**Meeting Minutes - Peer Review Process: Architecture Design Review Panel**  
**Rozelle Village**  
**Redevelopment of Balmain Leagues Club - Victoria Road, Waterloo Street and Darling Street, Rozelle**  
**Final issue: 111111**

**Date:** 28 October 2011  
**Meeting No:** Meeting 1/2: Concept Design Presentation  
**Location:** Rozelle Village Information Centre, Rozelle  
**Time:** 11.45am  
**Attendees:**  
***Panel Members***  
Ken Maher (KM) – Chairman, Hassell  
Helen Lochhead (HL) - NSW Deputy Government Architect  
Tony Caro (TC) – Director, Tony Caro Architects  
***Property Developers***  
Alex Yasumoto (AY) - Rozelle Village Pty Ltd  
Ian Wright (IW) - Rozelle Village Pty Ltd  
***Architects***  
Frank Stanisic (FS) - Stanisic Associates  
Jason Nowosad (JN) - Stanisic Associates (scribe)  
**Apologies:** None  
**Attachments** Concept Design Presentation

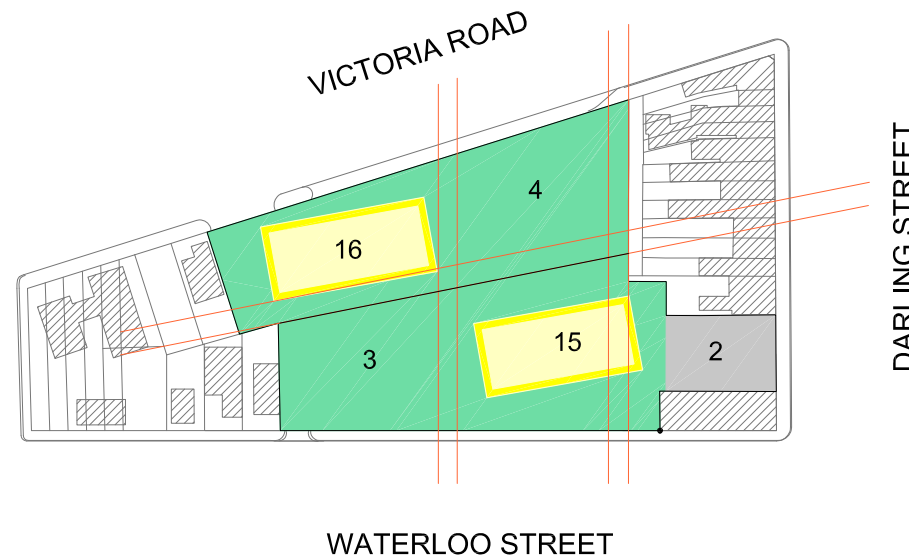
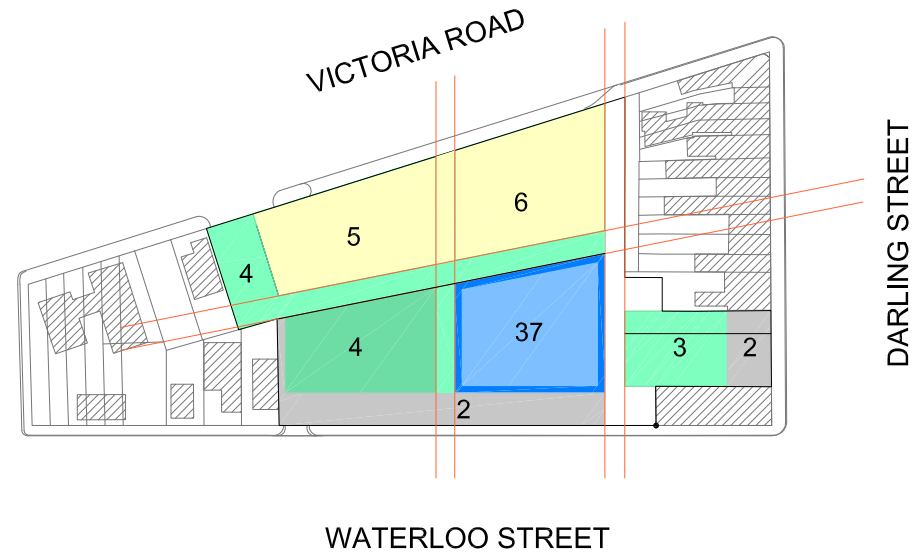
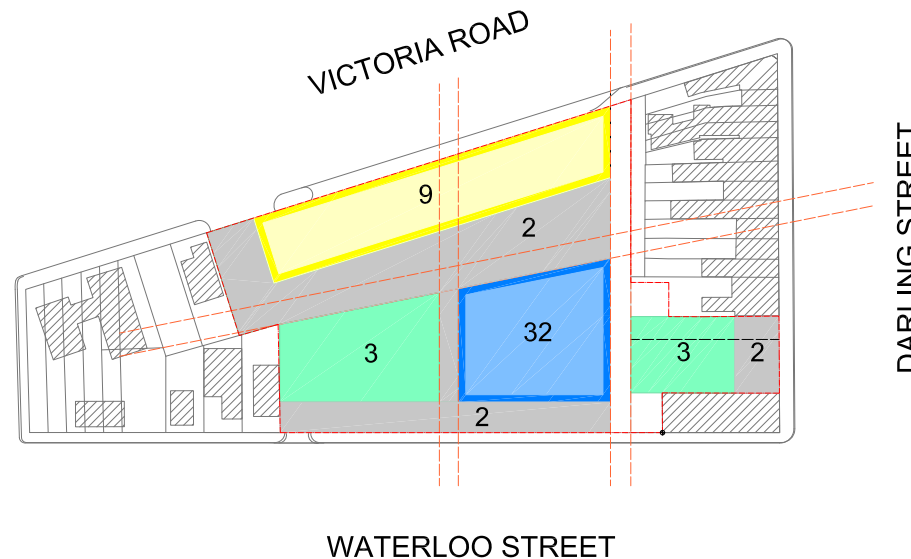
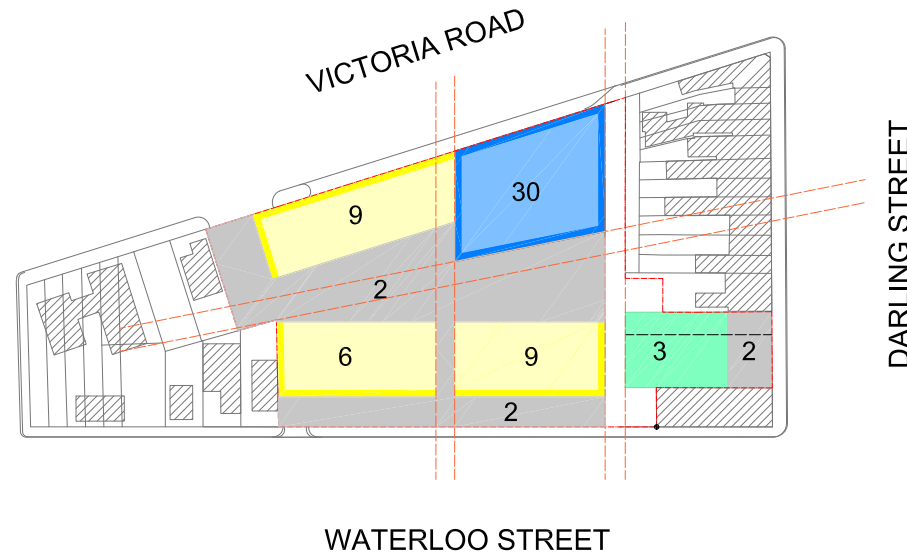
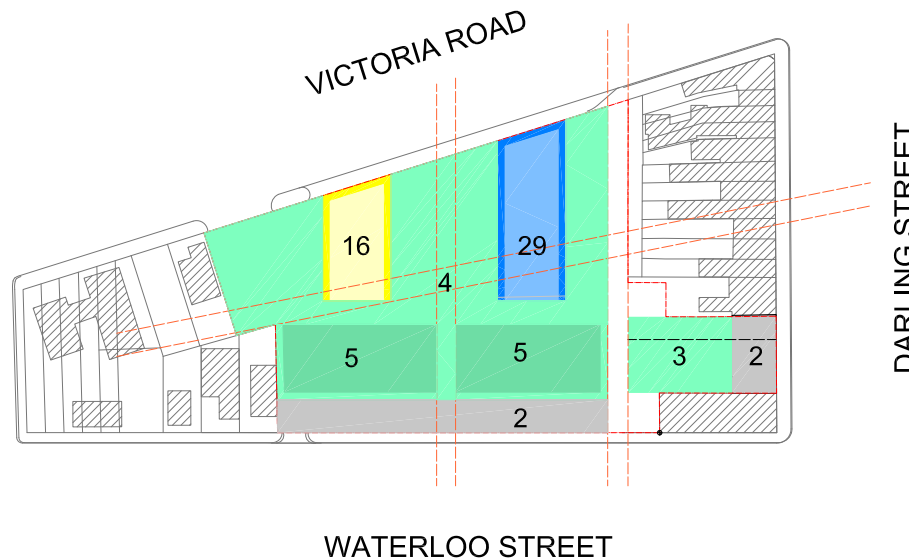
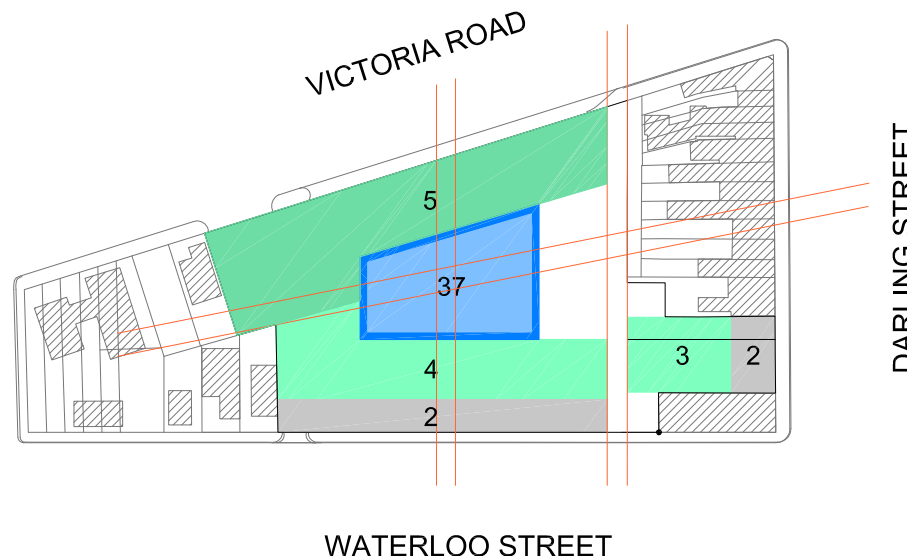
- FS tabled two building mass options for the site:
  - two towers/ flat top podium
  - single tower/ stepped podium
- HL questioned the size of a footprint of the two towers on the flat top podium option. FS commented that each tower has approximately 900sqm, totaling 1800sqm per floor.

- FS highlighted that the two towers on flat top podium option did not adjust to the street interface and was subsequently disconnected from the street.

- KM commented that the two tower/ flat top podium option would struggle to meet SEPP 65 requirements.
- FS commented that two tower/ flat top podium did not appear to have a key urban strategy or key shaping idea.

- TC commented that the two towers/ flat top podium option was not iconic ridge architecture.
- TC commented that two offset towers were good for visual privacy but not for SEPP 65 compliance.

- FS commented that the two tower/ flat top podium option presented a long street wall approximately 100m long.
- HL commented that it would be difficult to achieve a passively designed residential building if it was located adjacent to Victoria Road.

- KM commented that his instinct is that the two elements of the tower should have clearly different heights and be expressed differently.
- KM commented that the single tower/ stepped form was a better approach than a two tower/ flat top podium option and is generally endorsed by the panel.

- HL commented that the lack of a metro could potentially be offset by foot traffic and buses.
- KM commented that the shift from two towers. flat top podium to a single tower/ stepped podium is obvious and has many positive attributes.
